**Our ref:** NO/2014/107039/01-L01  
**Your ref:** 3/2014/0822  
**Date:** 23 September 2014

**REPLAN FOR PLOTS 32-45 ON RESERVED MATTERS APPLICATION 3/2013/0307  
WHICH ADDS AN ADDITIONAL 3NO. UNITS TO THE SCHEME**

**LAND OFF PRESTON ROAD, LONGRIDGE**

Drawing Title
REPLAN
PLOTS 32-45

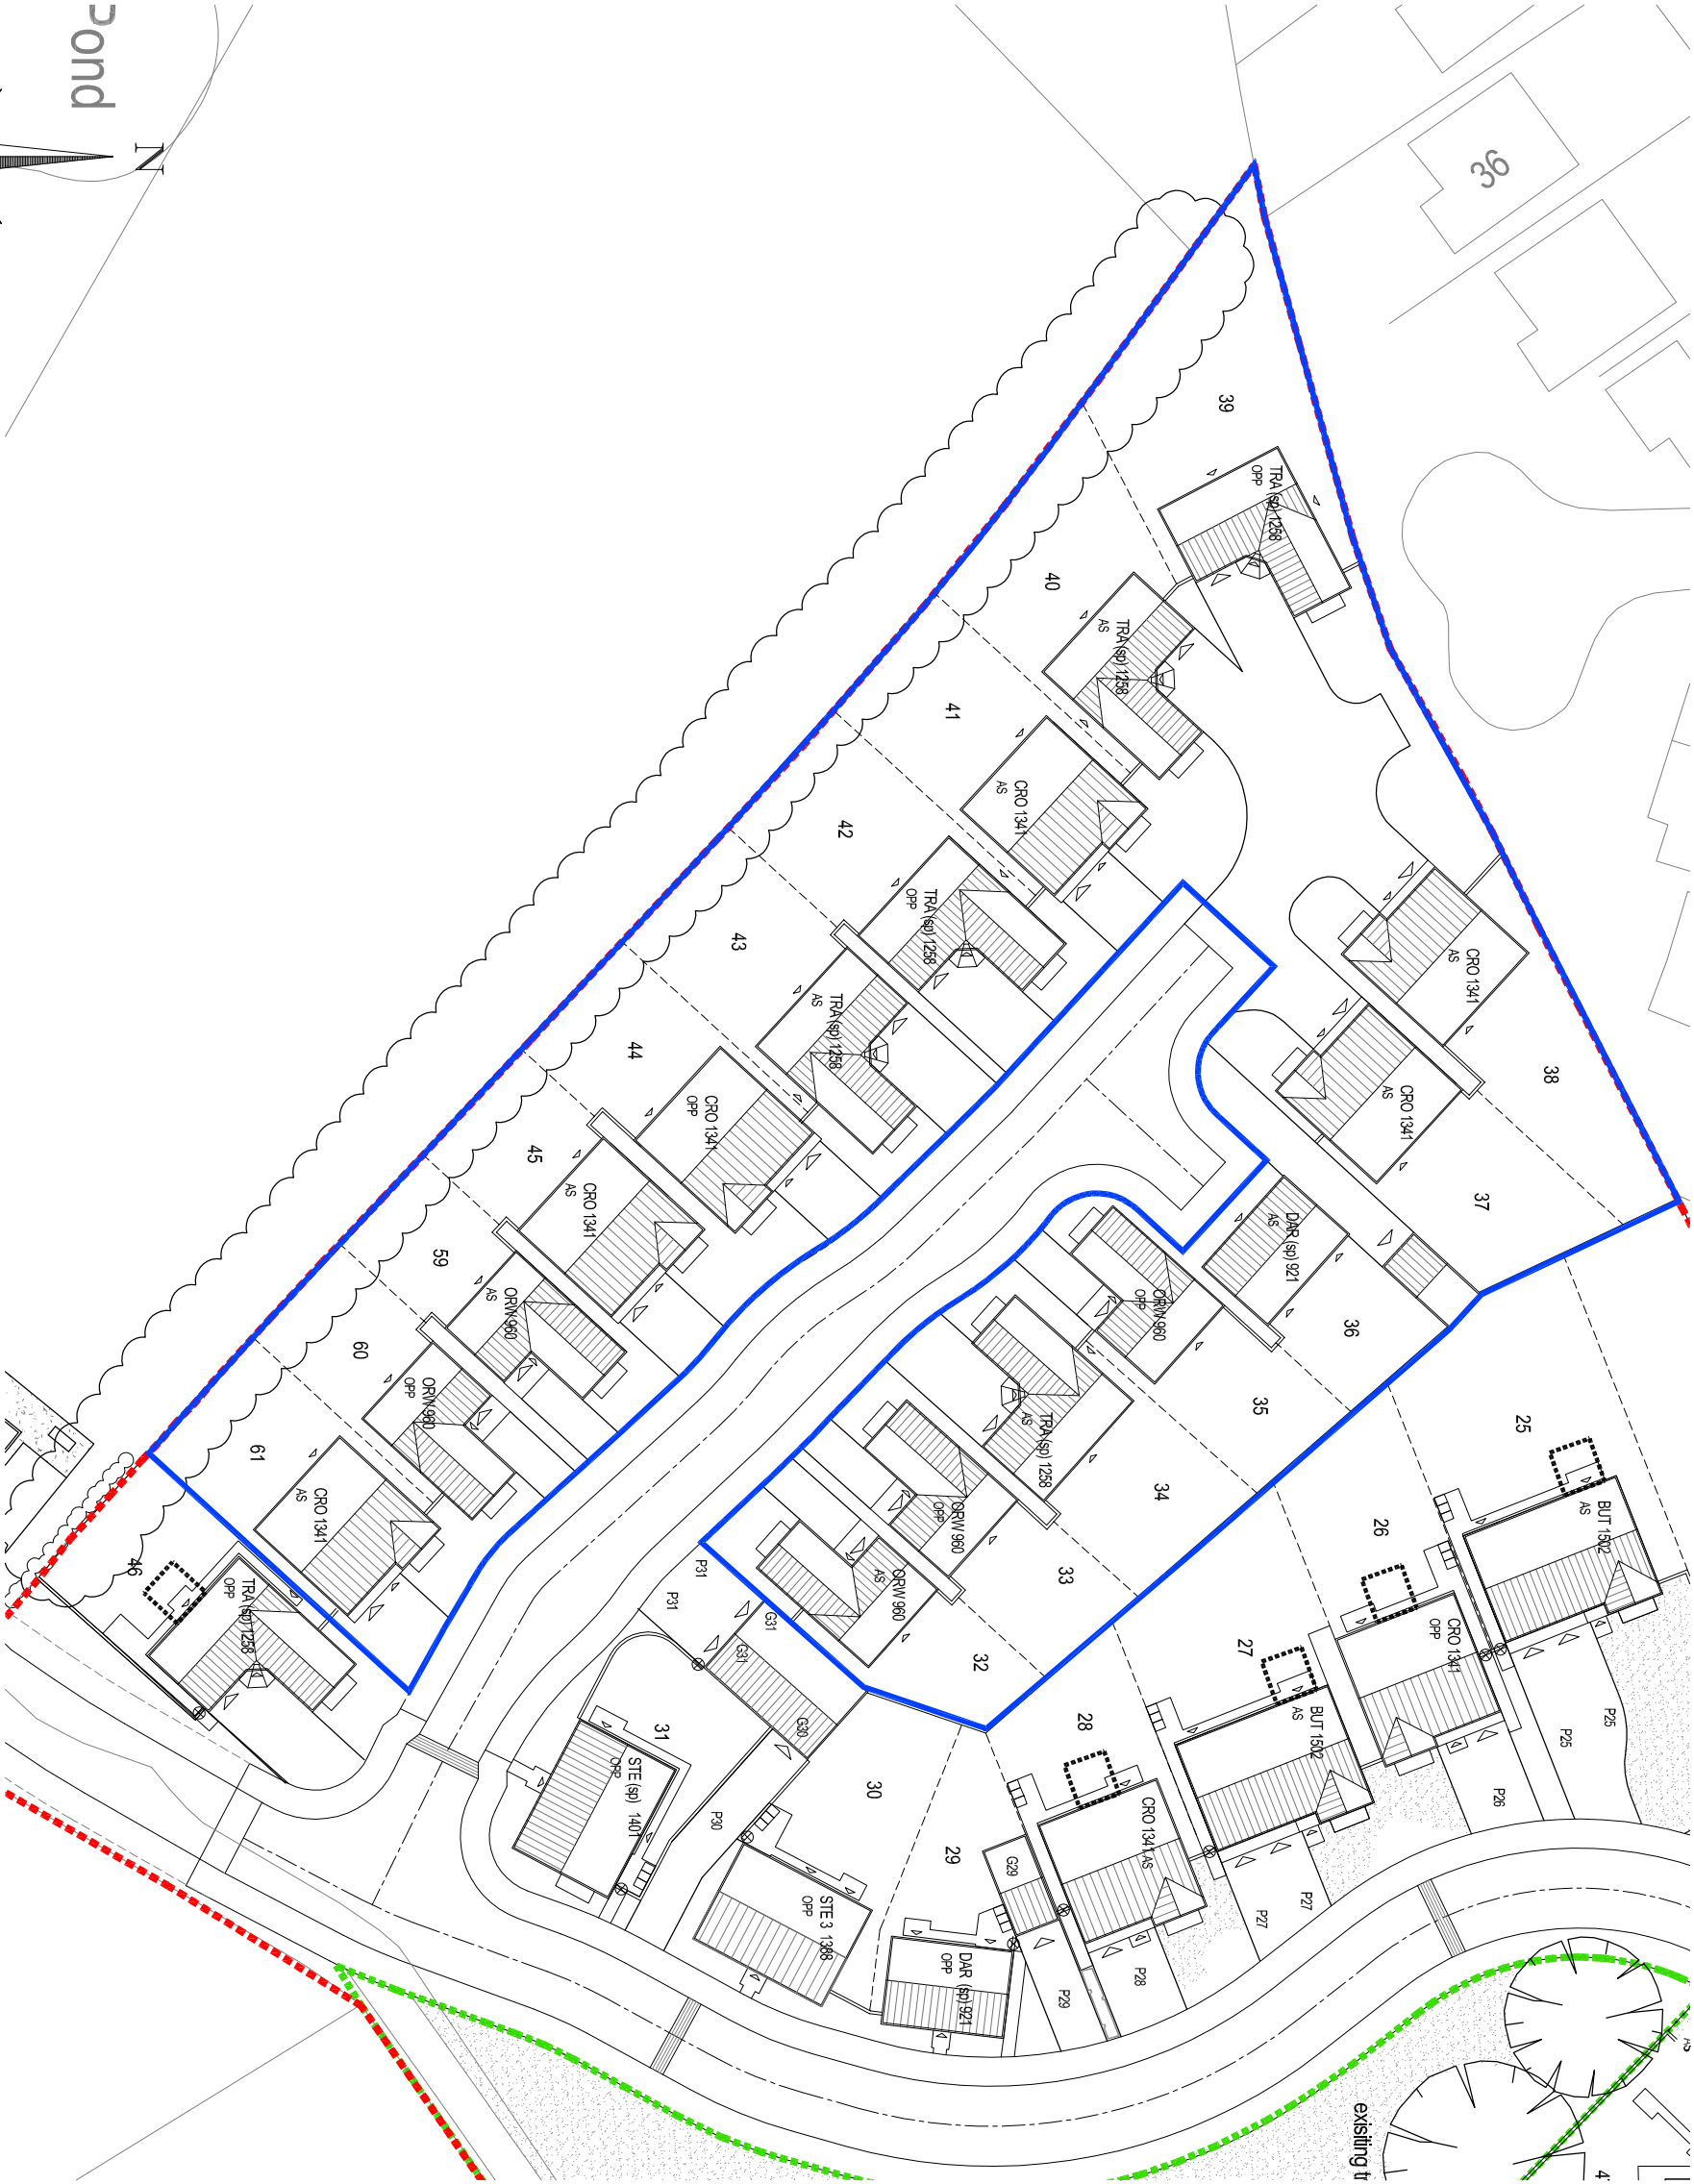
We have reviewed the information as submitted. Prior to the determination of this application, the applicant should submit details to demonstrate how the surface water drainage from this re-planned part of the development fits in with the drainage strategy for the entire site.
